From: Simon Davis
Sent: 04 April 2019 13:29
To: Angus Eitel [REDACTED]
Subject: FW: Planning Consultation on BN/14/19/DOC

Engineers Comments Regarding Condition 3- Surface Water Drainage Design

© This drawing is copyright It may not be copied or reproduced without written authority			
Scale	As shown	At original	A3
Drawing Number	2014/SK2		Revision -

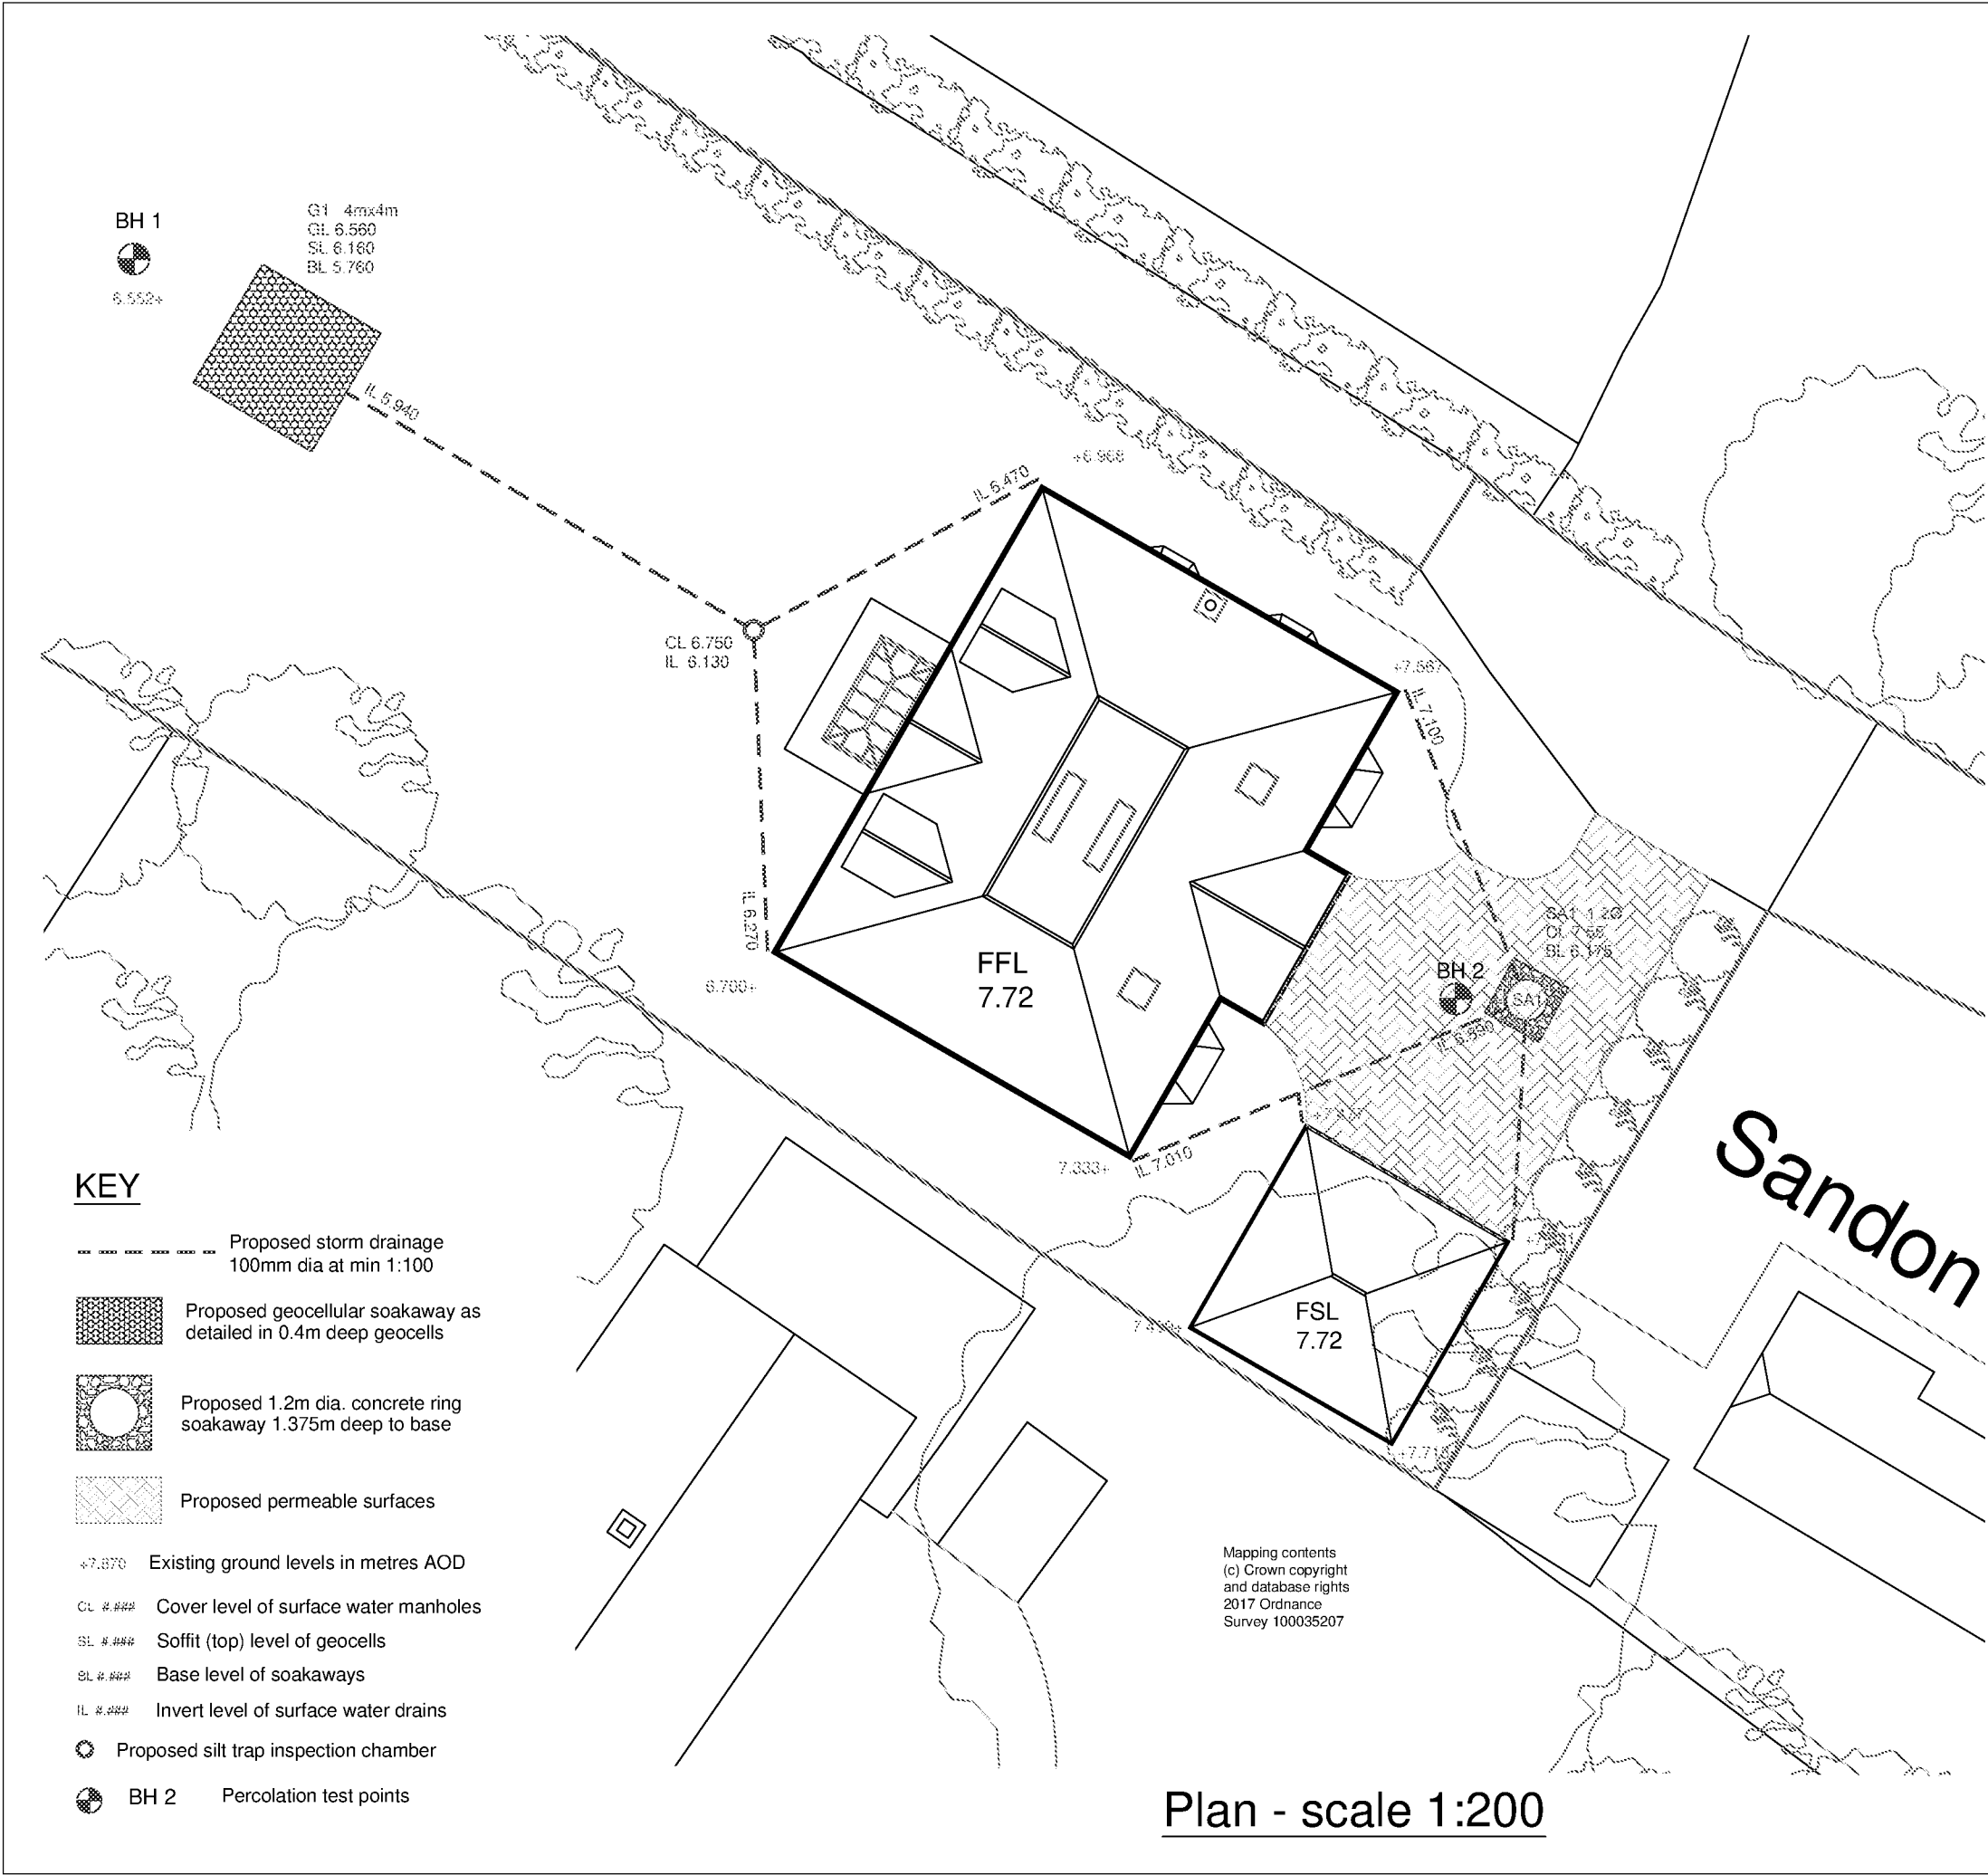
Winter groundwater monitoring and infiltration testing has been completed. The highest groundwater levels encountered were at 0.79m depth. It is unclear at which of the three monitoring locations that this peak occurred. Please can this be confirmed.

The soakaway that is proposed to be located in the rear garden has an invert level of 5.66m (0.9m below ground). The base of this soakaway must be located above the maximum recorded groundwater level, or adequate volume must be provided above the groundwater level.
